Ref No: DOC18/56755

Modification Request – Norwest Private Hospital Expansion - 11 Norbrik Drive, Bella Vista (SSD 6074 MOD 2)

RL : Approx 75.9

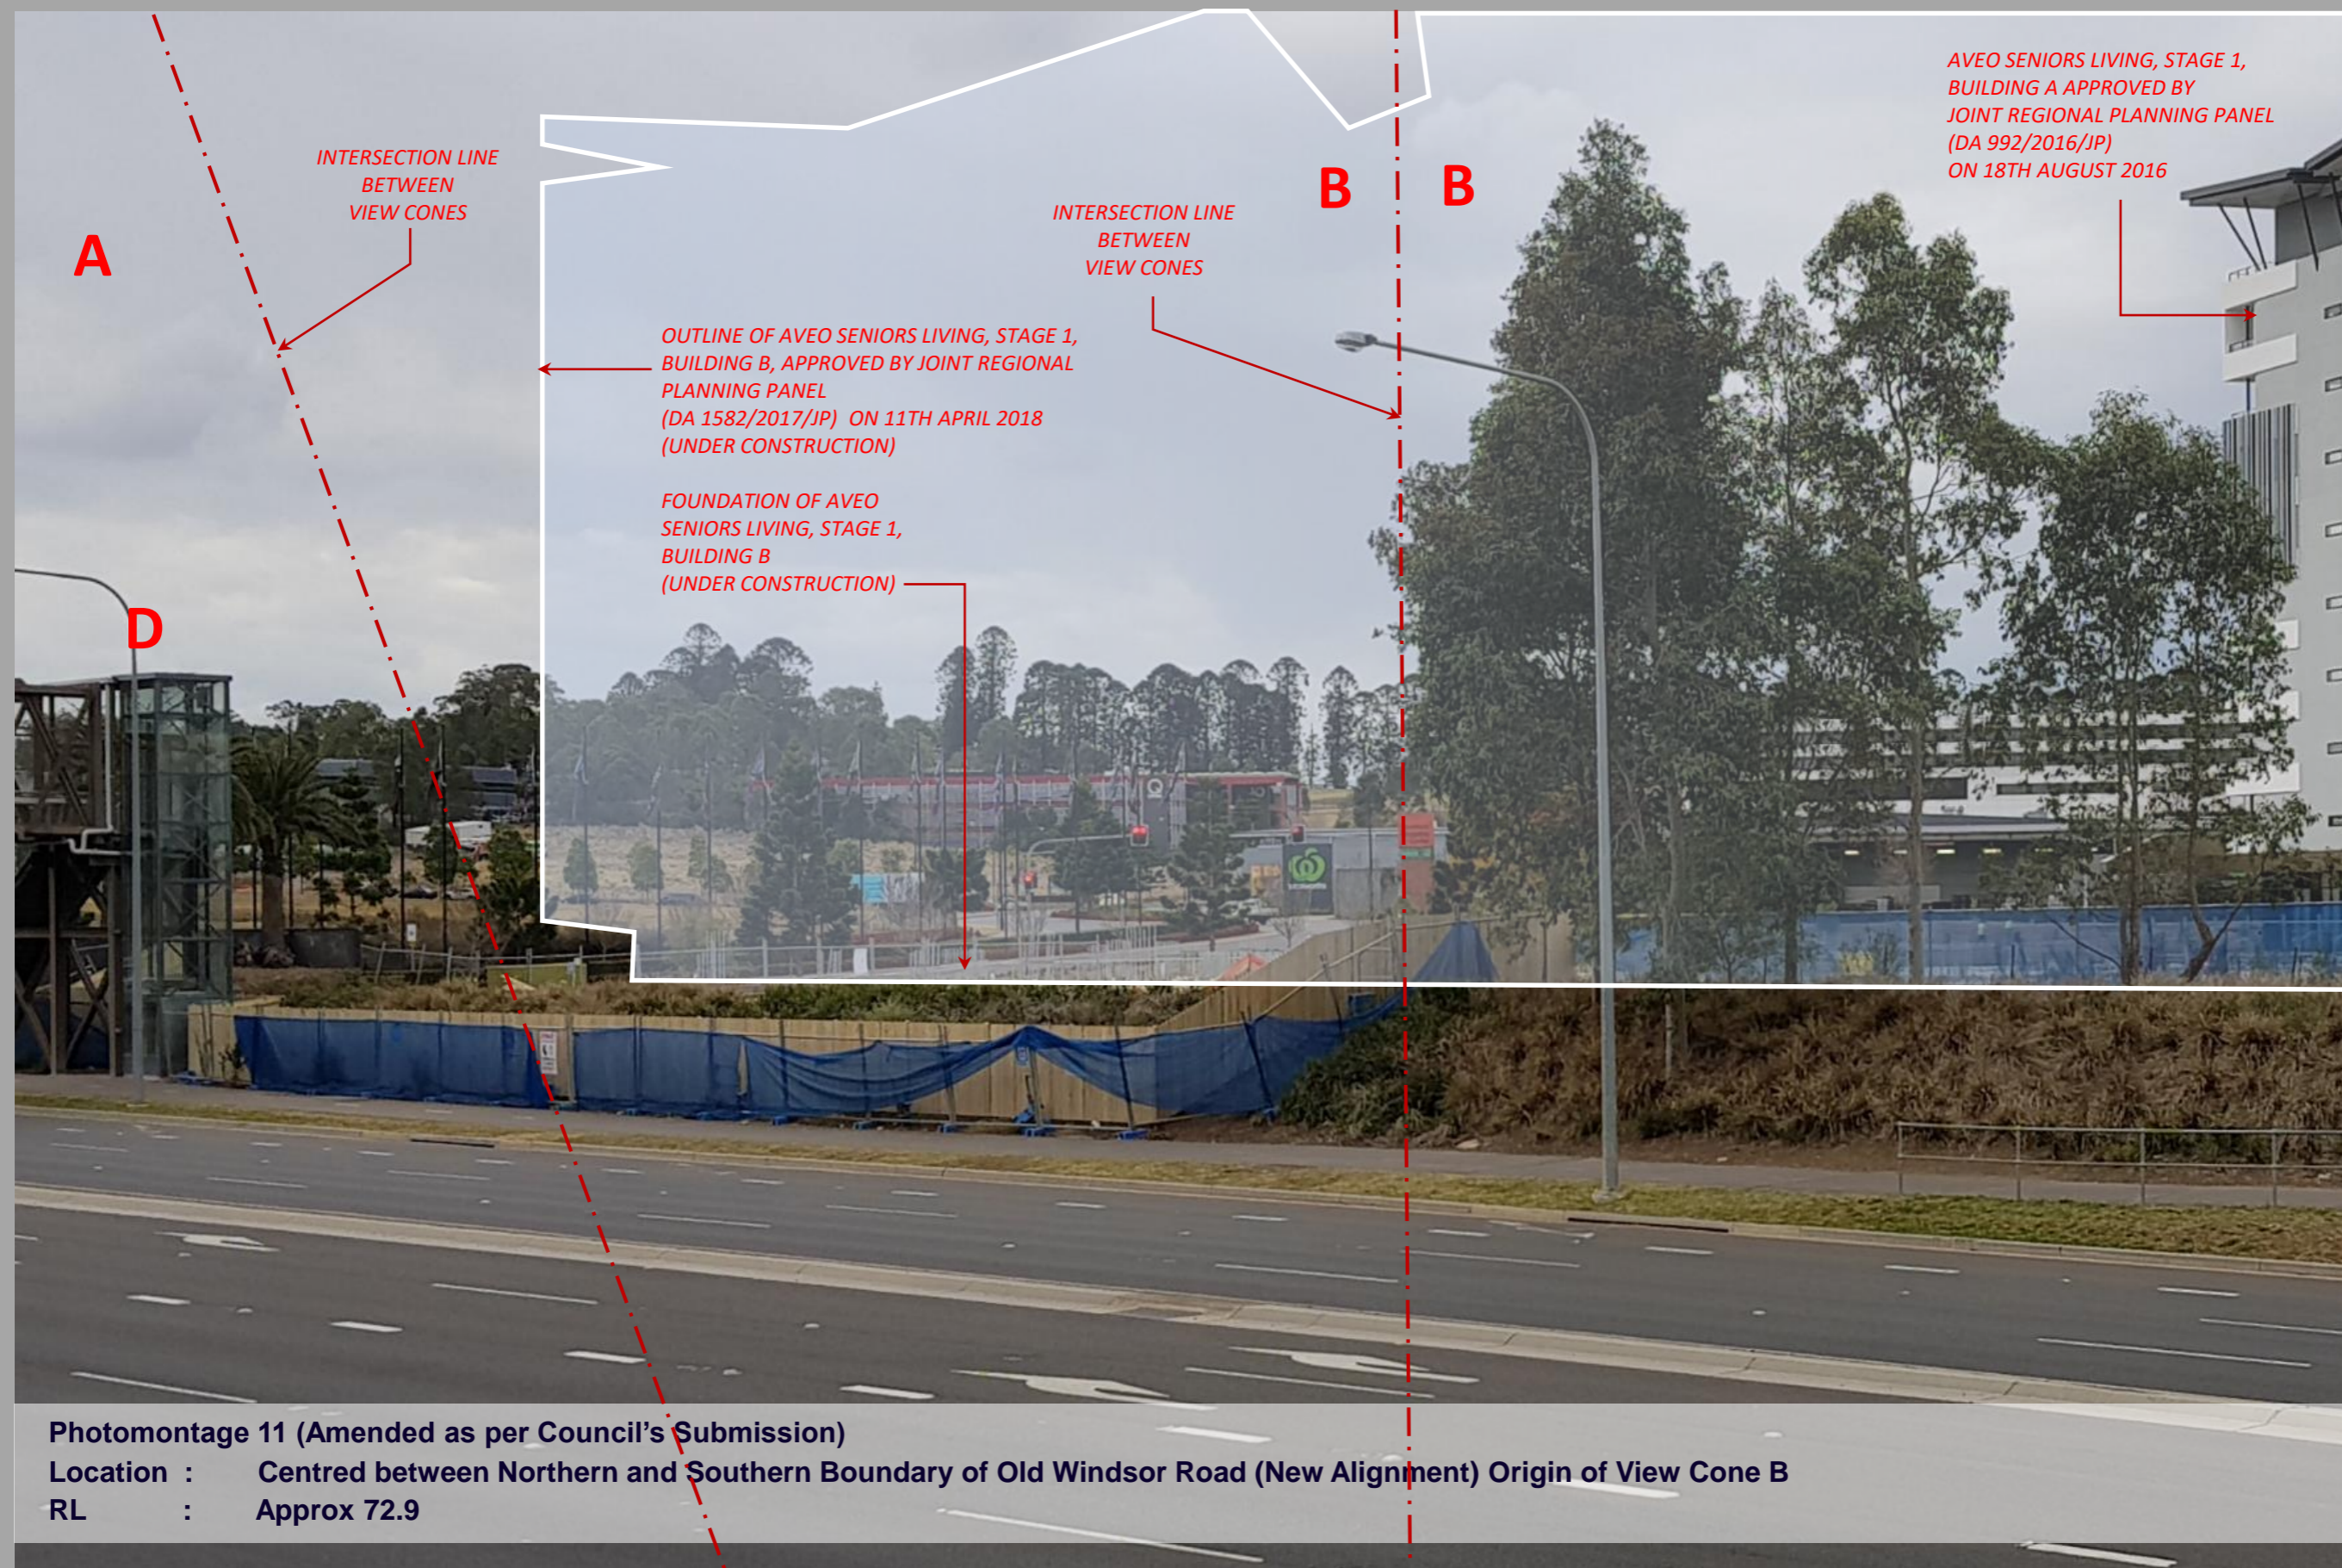
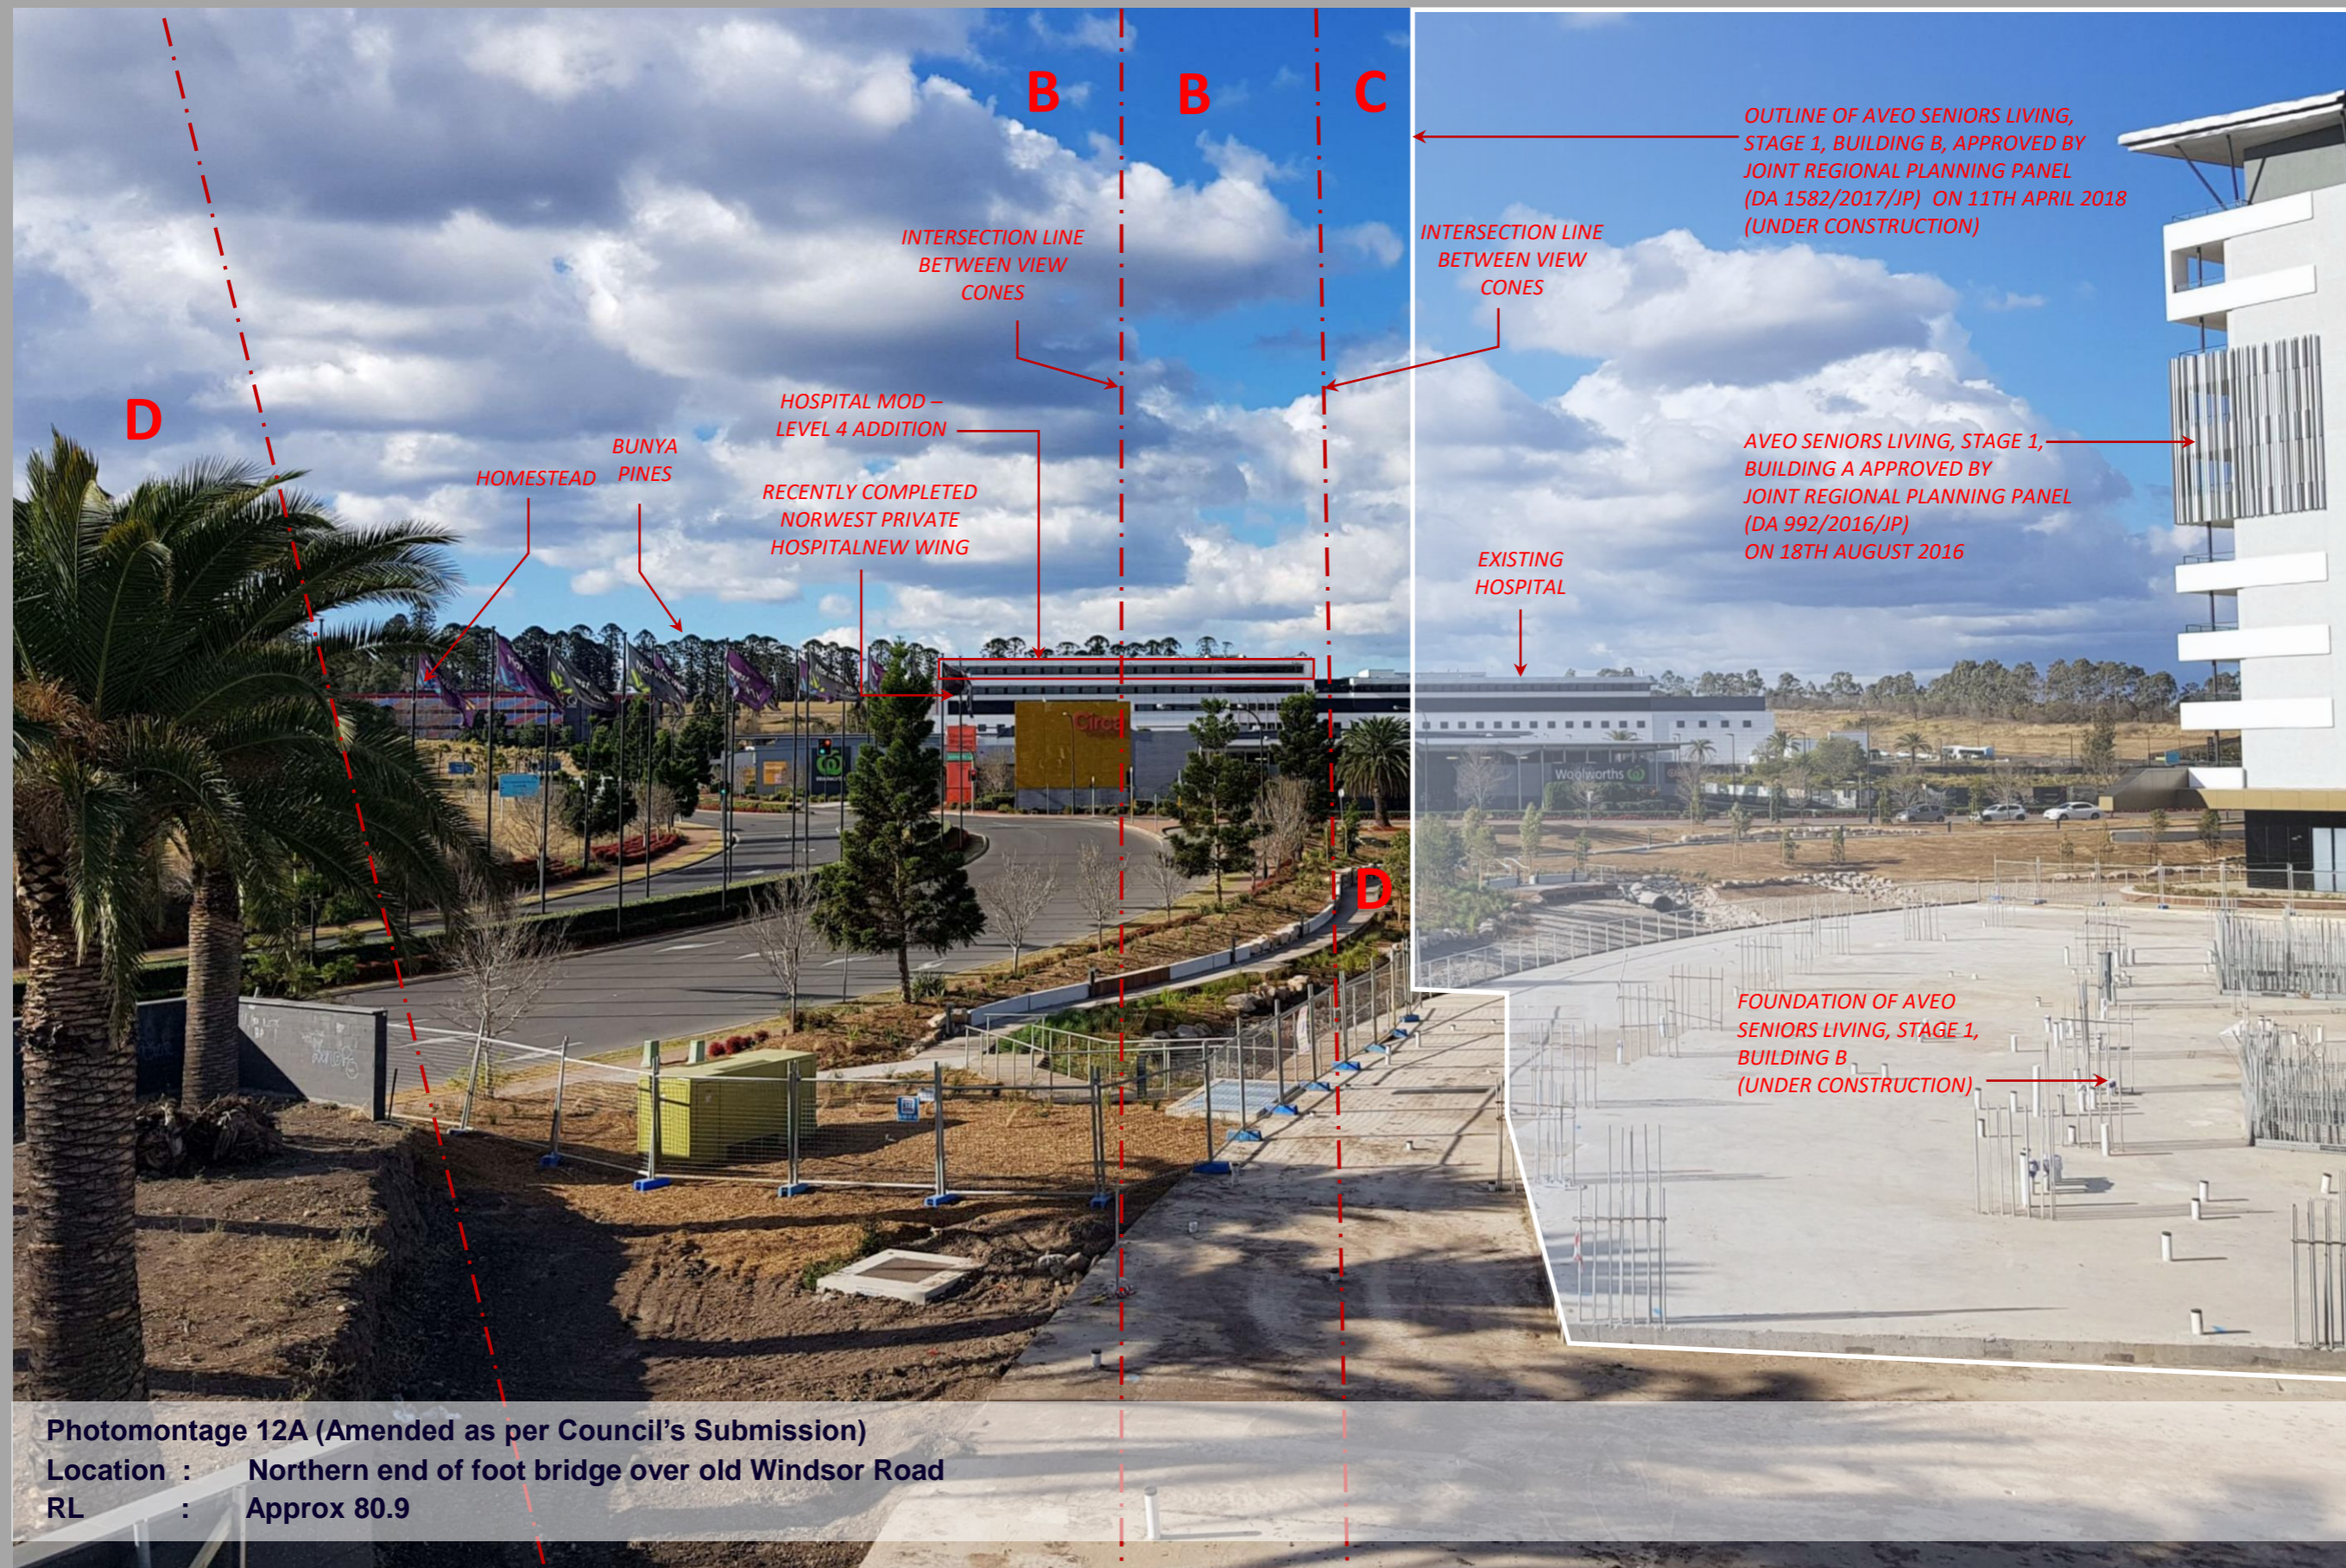
The relevant documentation has been reviewed, including the 'Bella Vista Homestead and Precinct Photomontage Study' prepared by Health Projects International, dated 21 February 2017. The study demonstrates that the proposed addition will retain significant views between *Bella Vista Farm* (including the homestead and Bunya Pine tree line) and the *Pearce Family Cemetery* which is also listed on the State Heritage Register (SHR no. 00593). The retention of these views is essential in understanding the historic association between the two heritage items. Subject to the retention of all identified significant views, no objection is raised.
